RESPONSE TO PLAT ITEMS
IN RED

Review Comments (21)

PCD Engineering Division	<p>Review 1 comments will be uploaded by the project manager. Please address comments on the following documents:</p> <ul style="list-style-type: none">-Drainage letter-Final Plat - SEE ITEMS IN RED ON PLAT MARKUP-Letter of Intent <p>Reviewed by: Lupe Packman Review Engineer lupepackman@elpasoco.com</p>	2/22/2022 4:01:47 PM

FLYING HORSE NORTH FILING NO. 2

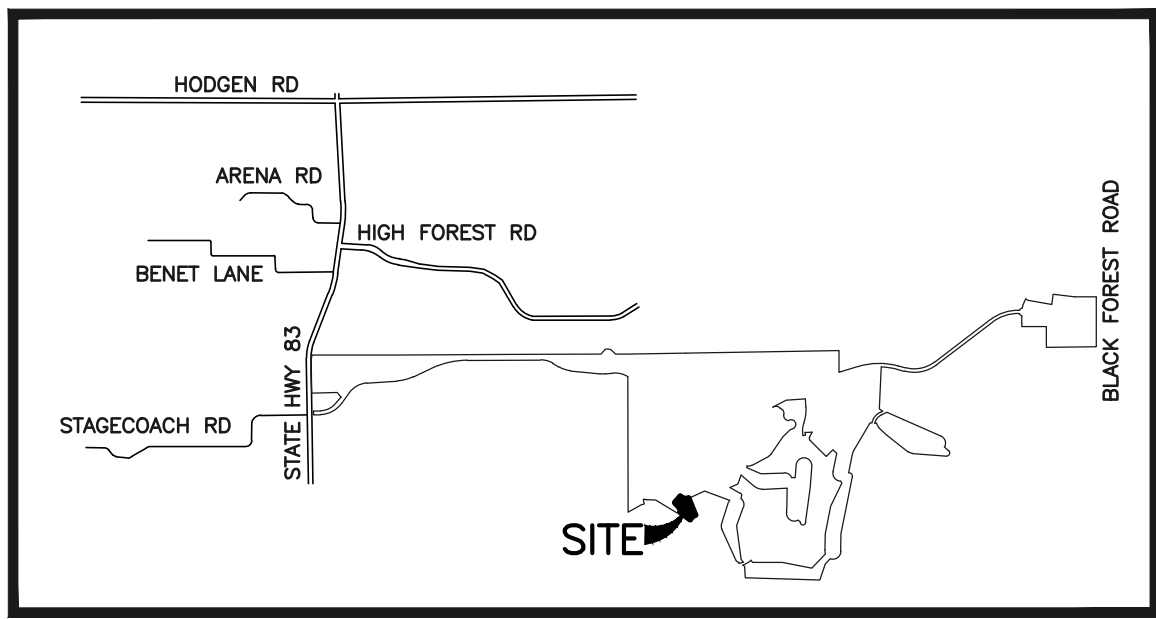
1. If Filing NO. 1 was only to plat up to lot 81 on Quartz Creek Drive, will or has Quartz Creek Drive been built out to give this lot access to this street and to Coffey Street? Coffey Street is not labeled on page 2, so I am assuming it is not being built out with this plat. Also, this lot looks as though from the master plan that this is no longer a flag lot, as proposed to be lot 91 from the master plan. Is there a new PUD to show the new configuration? Where is the access to this lot?

2. Enumerations cannot assign an address to a lot that does not have access to a street. Please clarify.

Access road from Quartz Creek Dr to this parcel appears to be a modified version of the original Coffey St which is already approved and reserved.

The streetname should be depicted on the plan drawings

Note: The layout in this drawing is significantly different than the previous plans submitted.
The letter of intent states "Following the proposed alignment of Coffey Street, this is an interim measure until Coffey Street is constructed, connecting to Quartz Creek Drive."

By all appearances, the cutting of roadways that align to the original plan drawings have already begun in this area. Is the intention then to cut a new road for access to this parcel temporarily?

ACCESS WILL BE TEMPORARILY
OVER THE EASEMENT
SHOWN ON THE PLAT
UNTIL A ROAD IS
PLATTED TO THE LOT.

ACCESS TO THE LOT
WILL BE FROM
QUARTZ CREEK DRIVE
UNTIL A ROAD IS
PLATTED TO THE
LOT.

FLYING HORSE NORTH FILING NO. 2

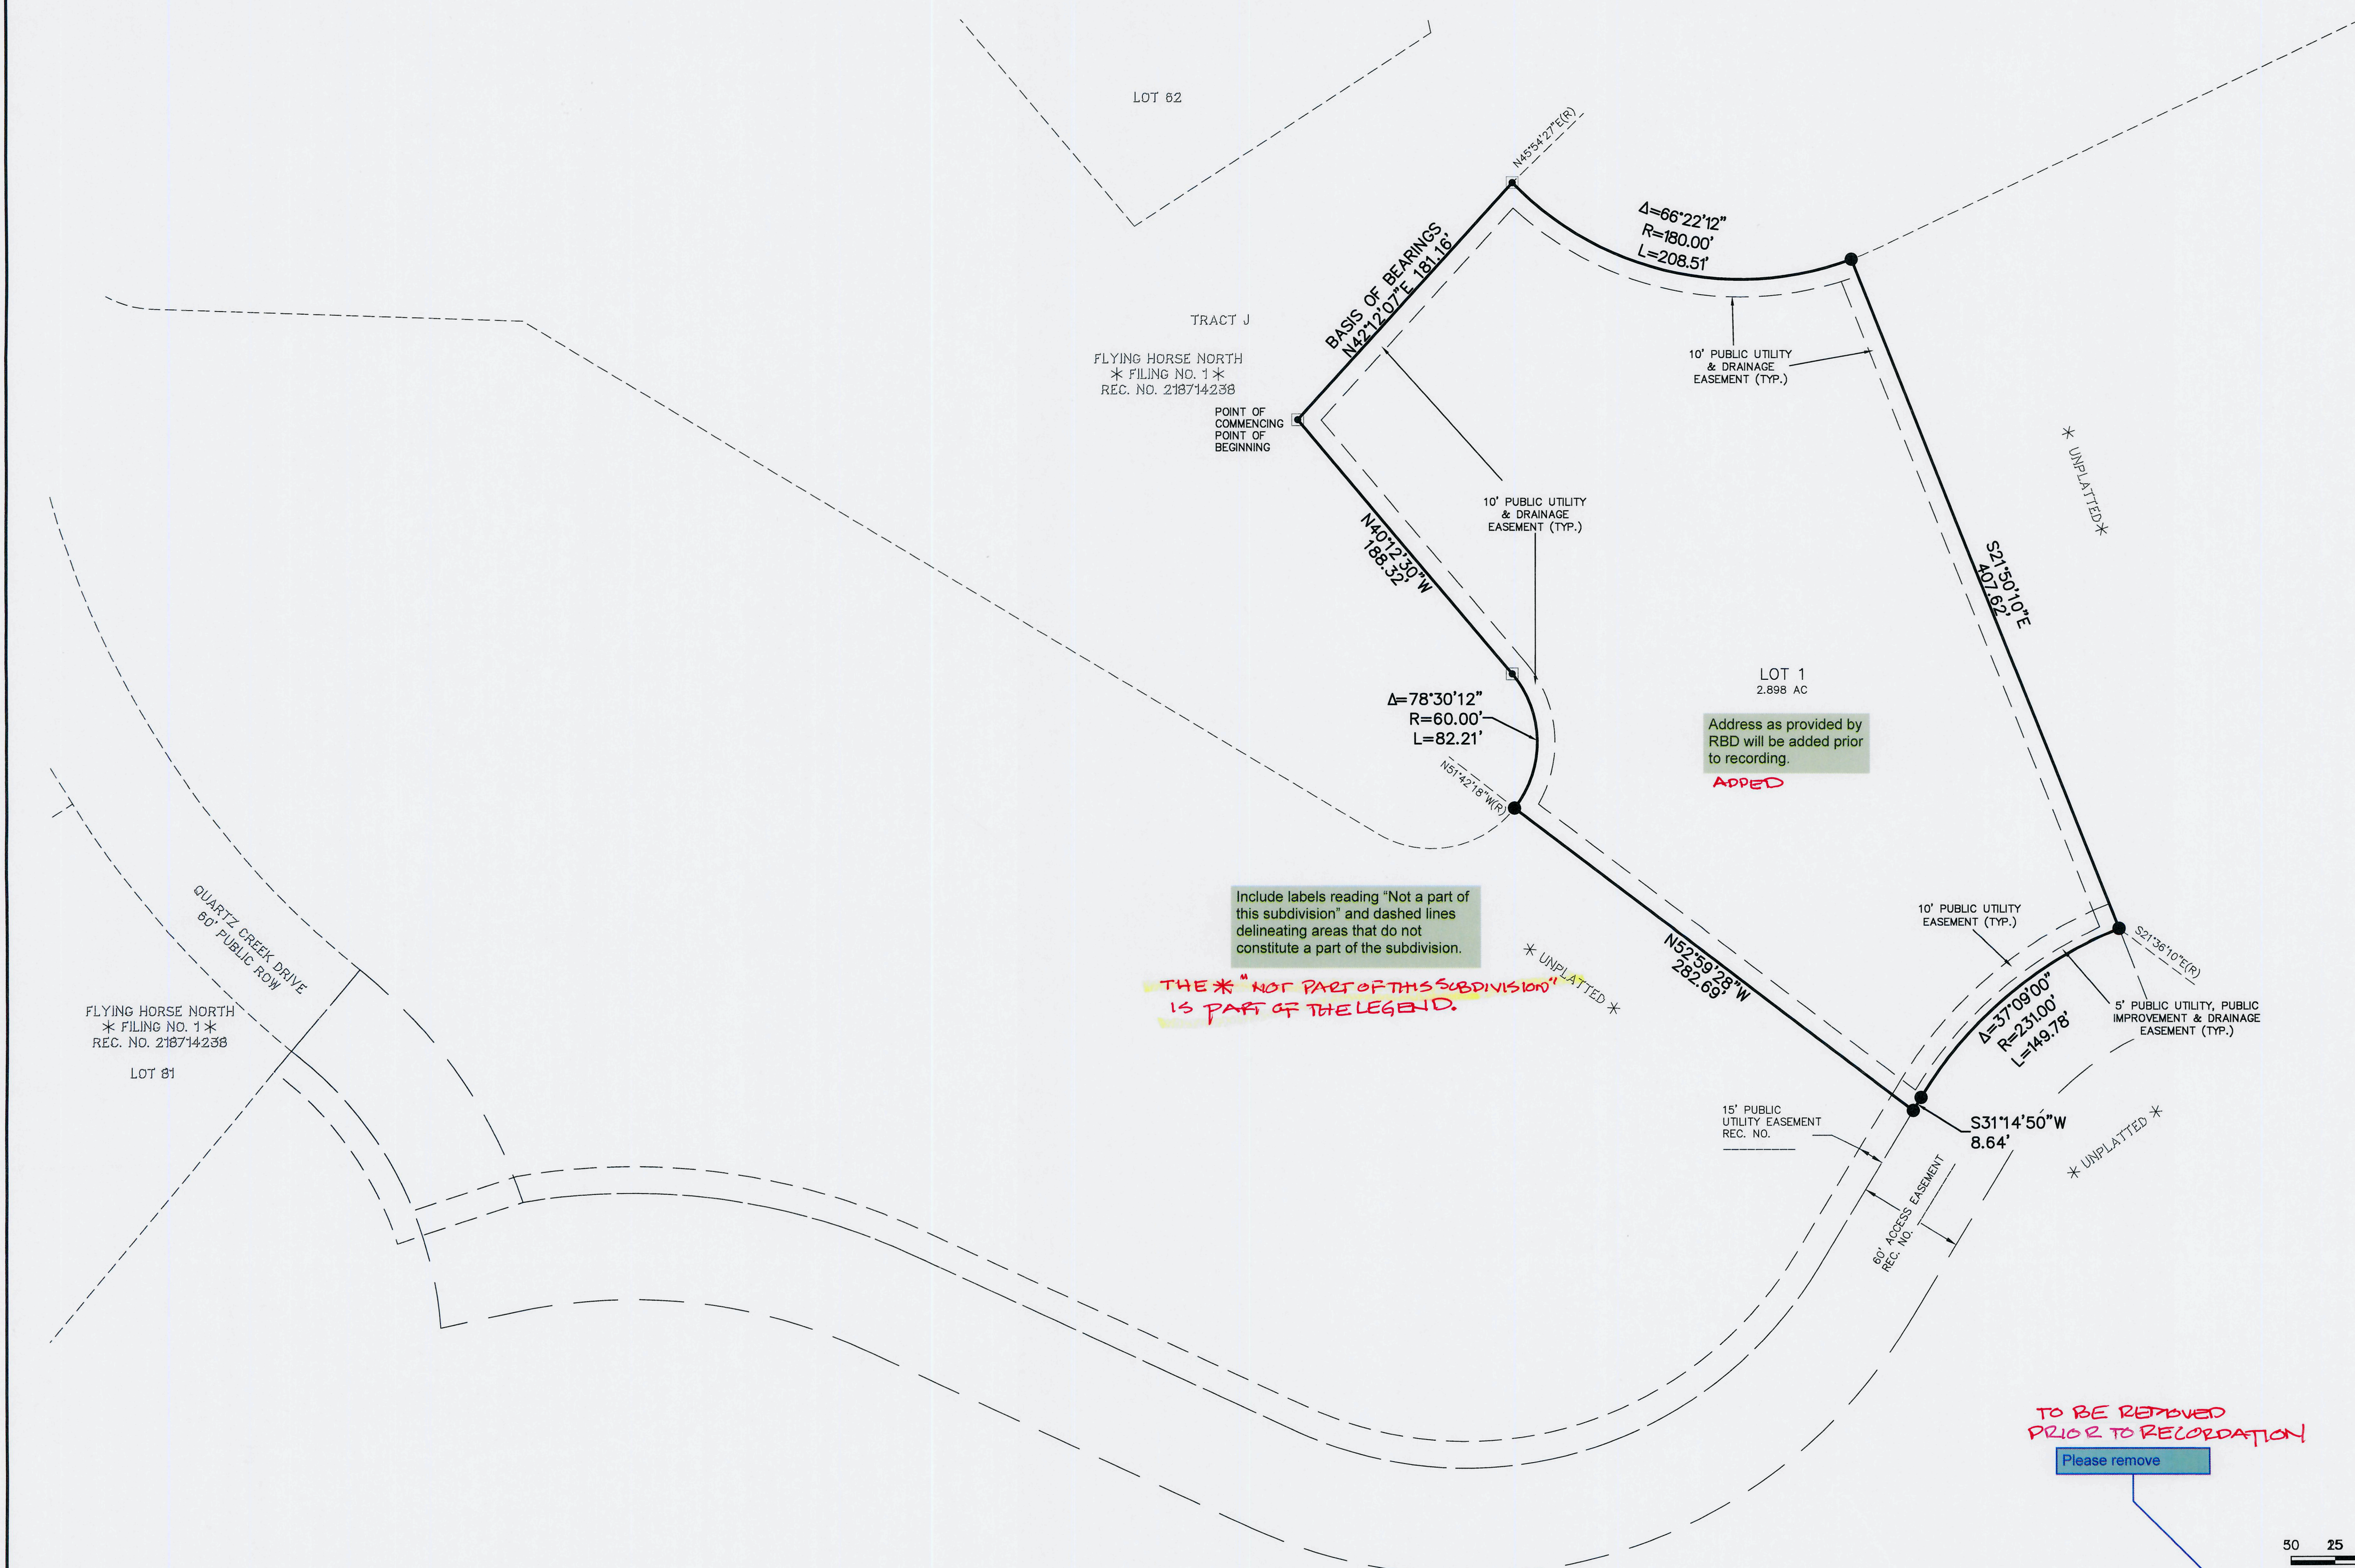
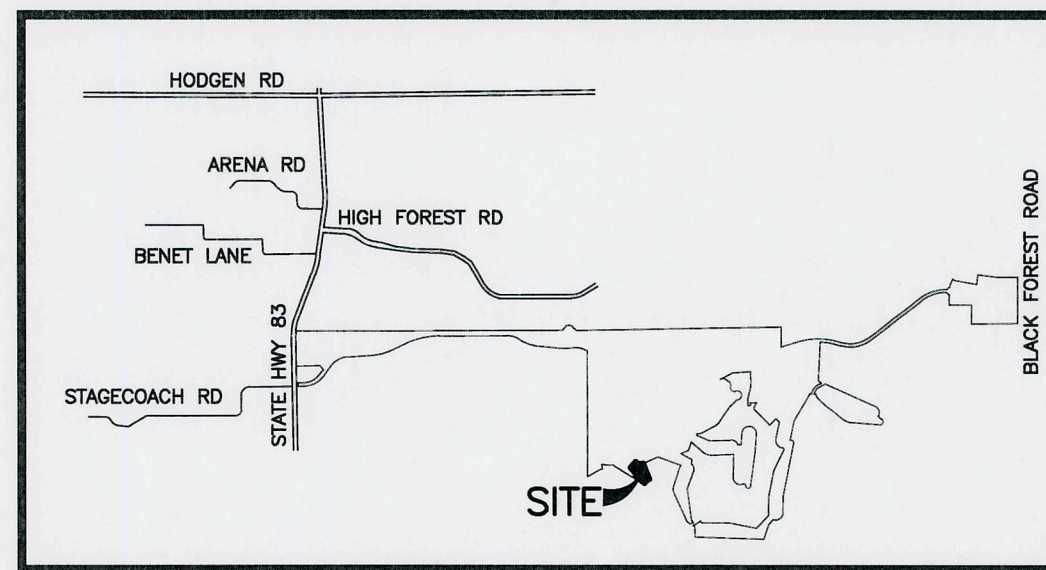
CGS recommends delineation on the plat of a non-buildable setback from the crest of the steep slope. This will probably require a plat showing topographic contours, which should have been provided at preliminary plat. CGS was not referred on the Flying Horse North Filing No. 2 preliminary plat. In accordance with Section R403.1.7.2 of the 2015 International Residential Code, Footing setback from descending slope surfaces, and Section 1808.7.2 of the 2015 International Building Code, Foundation setback from descending slope surface, a setback of 40 feet or $1/3 \cdot$ the height of slope, whichever is smaller, is required from the crest of descending slope surfaces. In this case, a non-buildable setback of at least 15 feet from the slope crest is required.

NOTE 28 ADDED TO
PLAT WHICH REFERENCES
THE MITIGATION
MEASURES AND
CONSTRAINTS IN
THE SOILS REPORT
